A47/A11 Thickthorn Junction

8.4 Statement of Common Ground with Highways England and Historic England

STATEMENT OF COMMON GROUND – HISTORIC ENGLAND

Version	Date	Status of Version
Rev. 0	March 2022	Deadline 10

HE551492-GTY-EGN-000-DR-LX-30008

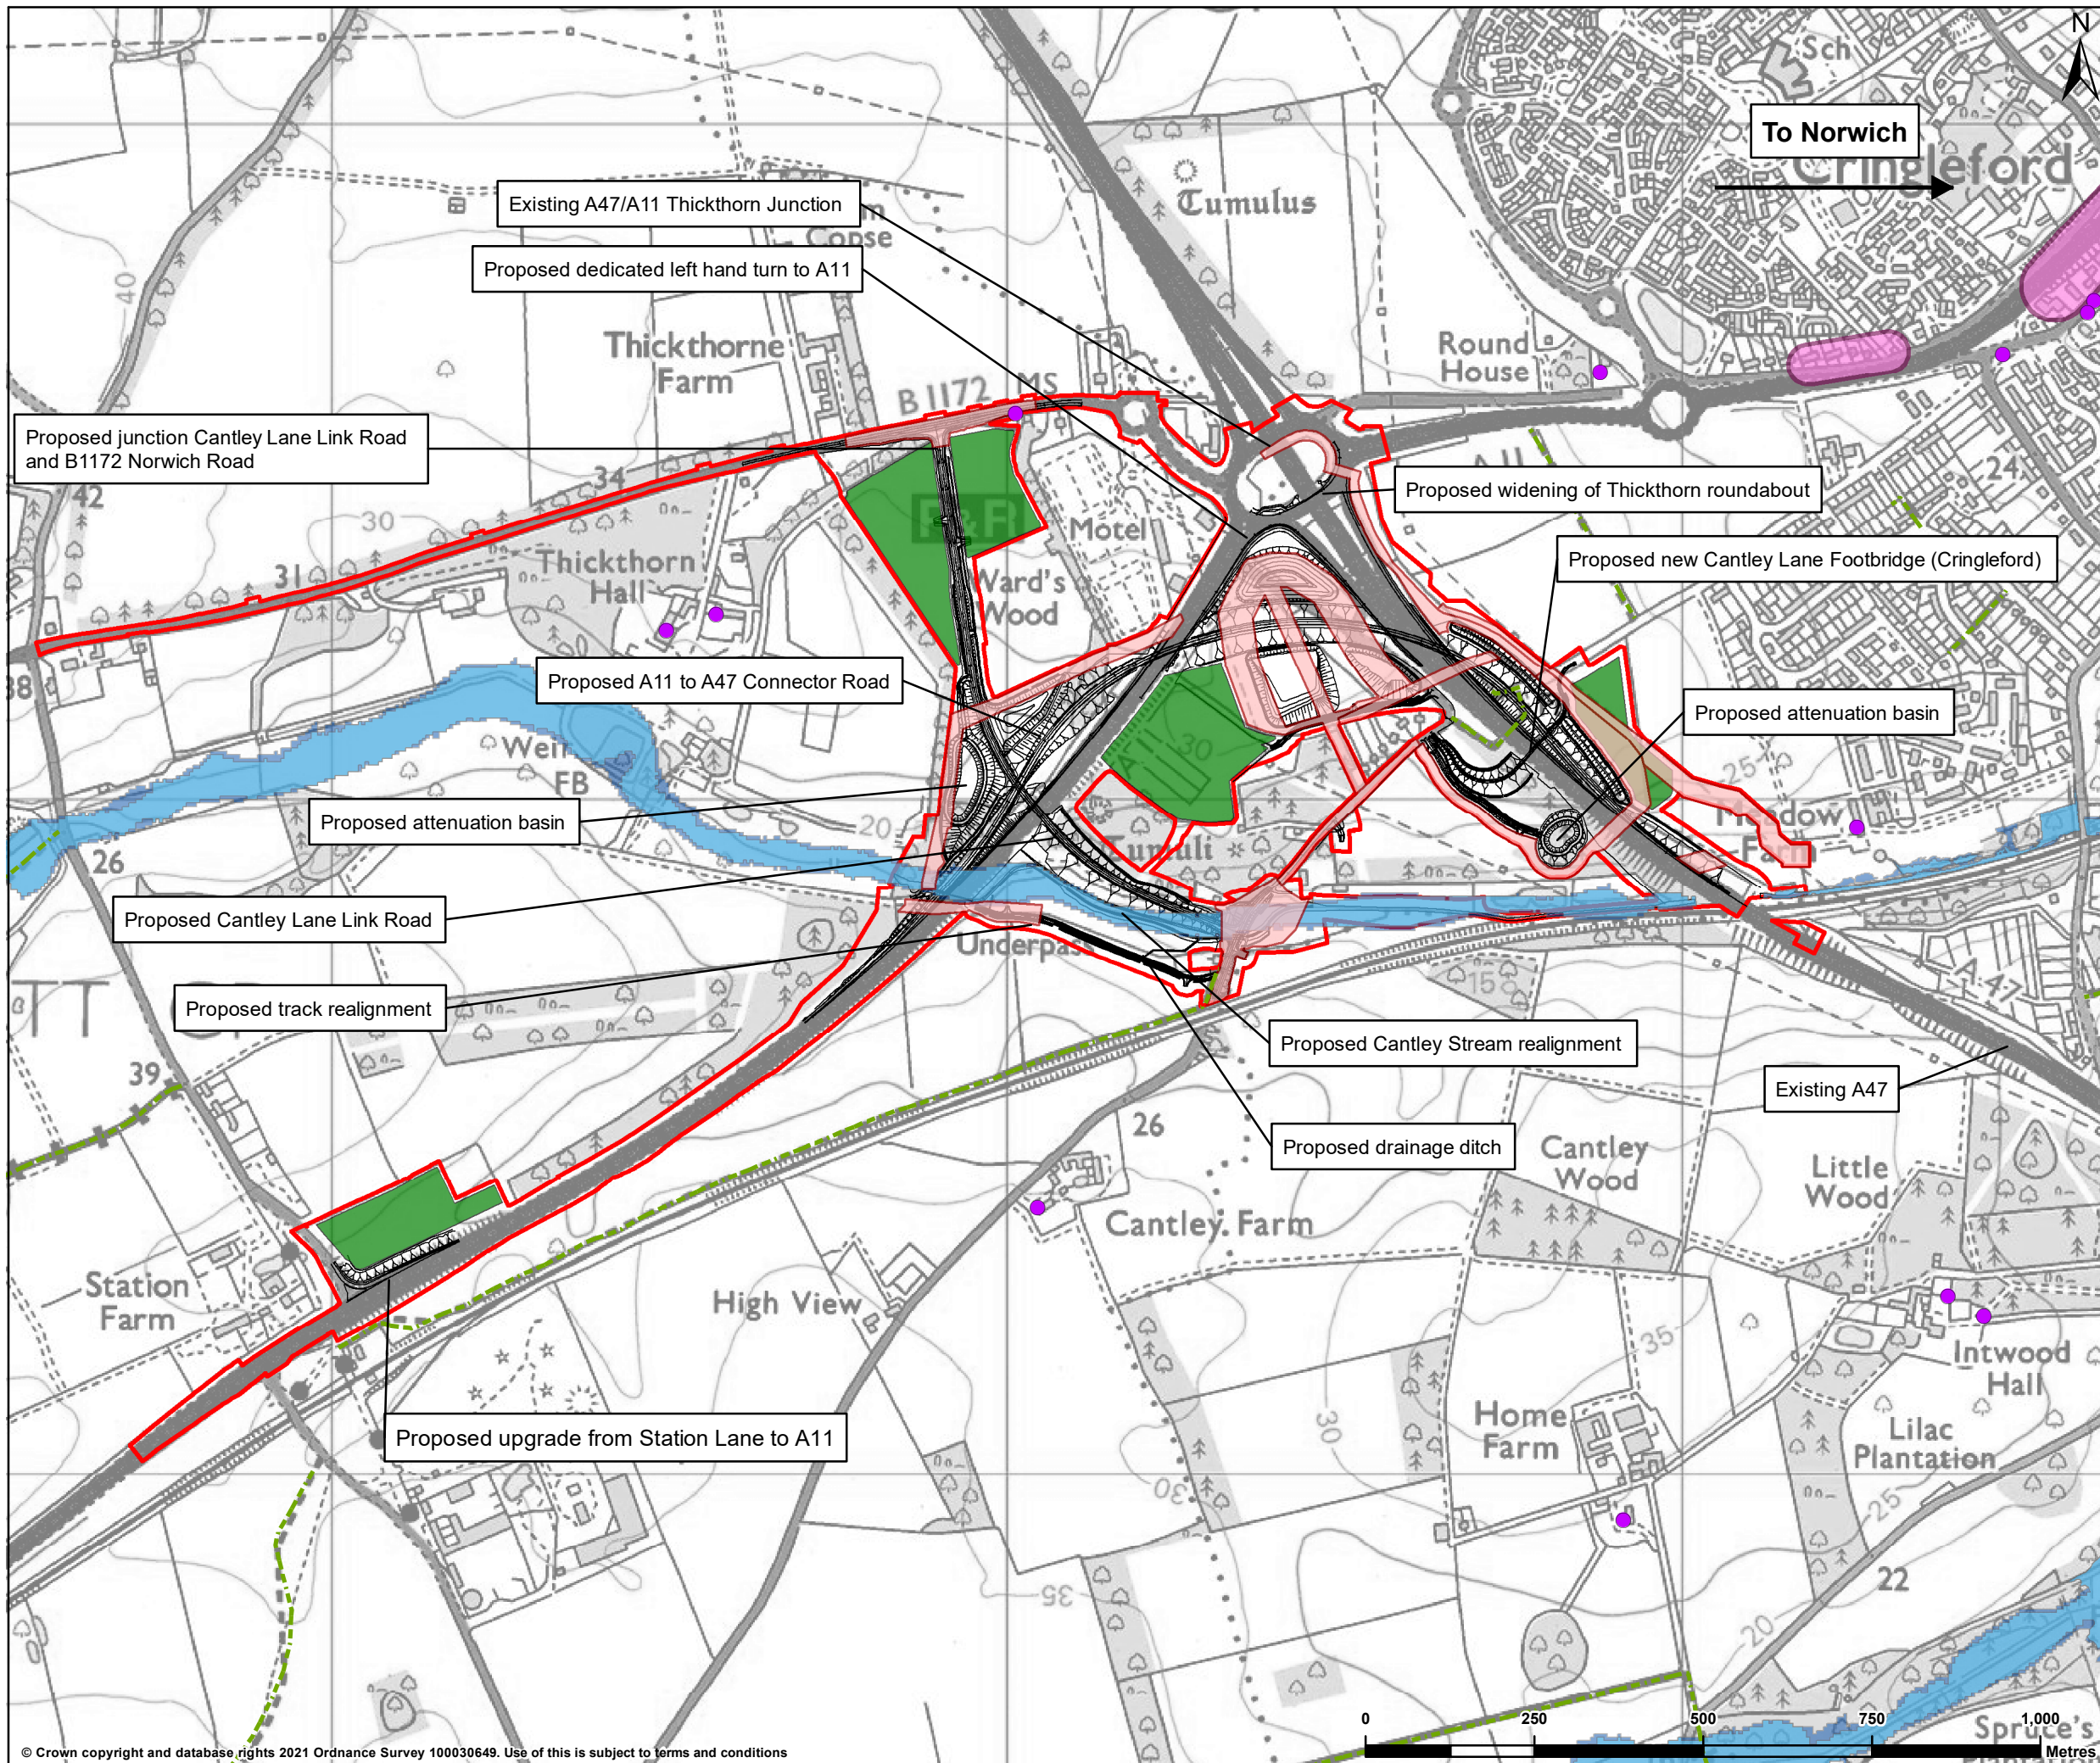
Reference	Relevant Representation	Highways England Response	Status
	<p>adjacent to the scheduled monument with the applicant's heritage consultant and Norfolk County Council. Section 6.10.7 of the ES identifies that the proposed scheme would have a 'significant residual adverse effect' on the scheduled monument. This would arise through a permanent change to the setting of the monument and the severance of the barrows from their landscape context overlooking a small valley to their south. We consider that the change to the setting of the 'Two tumuli in Big Wood' scheduled monument would result in harm to the significance of this designated heritage asset. The level of harm will need to be weighed against the public benefit of the proposed scheme.</p>		
RR-005.2	<p>3. Non-Designated Heritage Assets Chapter 6 of the ES identifies a wide range of non-designated heritage assets within the DCO application boundary and wider study area. The archaeological surveys already undertaken have identified previously unrecorded buried archaeological remains and a high potential for further such heritage assets to be present within the application site boundary. We note that further field survey would be necessary to fully establish the archaeological potential of the proposed development area. A 'Compound/Material Storage Area' is shown southeast of the existing A11 on Figure 2.1. This area was not included in the archaeological surveys and we are concerned that it could impact on as yet unidentified heritage assets. We request clarification regarding the potential impact in this area, and whether archaeological surveys are proposed for this.</p>	<p>Supplementary trial trenching was completed December 2021 which included a series of hand dug trial pits in the area adjacent to the scheduled monument. The supplementary survey covers areas that were not surveyed during the 2020 trial trenching. The final report is awaited (to be submitted to the Examining Authority at Deadline 7) however initial results showed no archaeological remains.</p> <p>In consultation with the county archaeologist, trial trenching only is proposed at the location of the Compound/Material Storage Area shown southeast of the existing A11 on Figure 2.1 (APP-054)</p>	Agreed
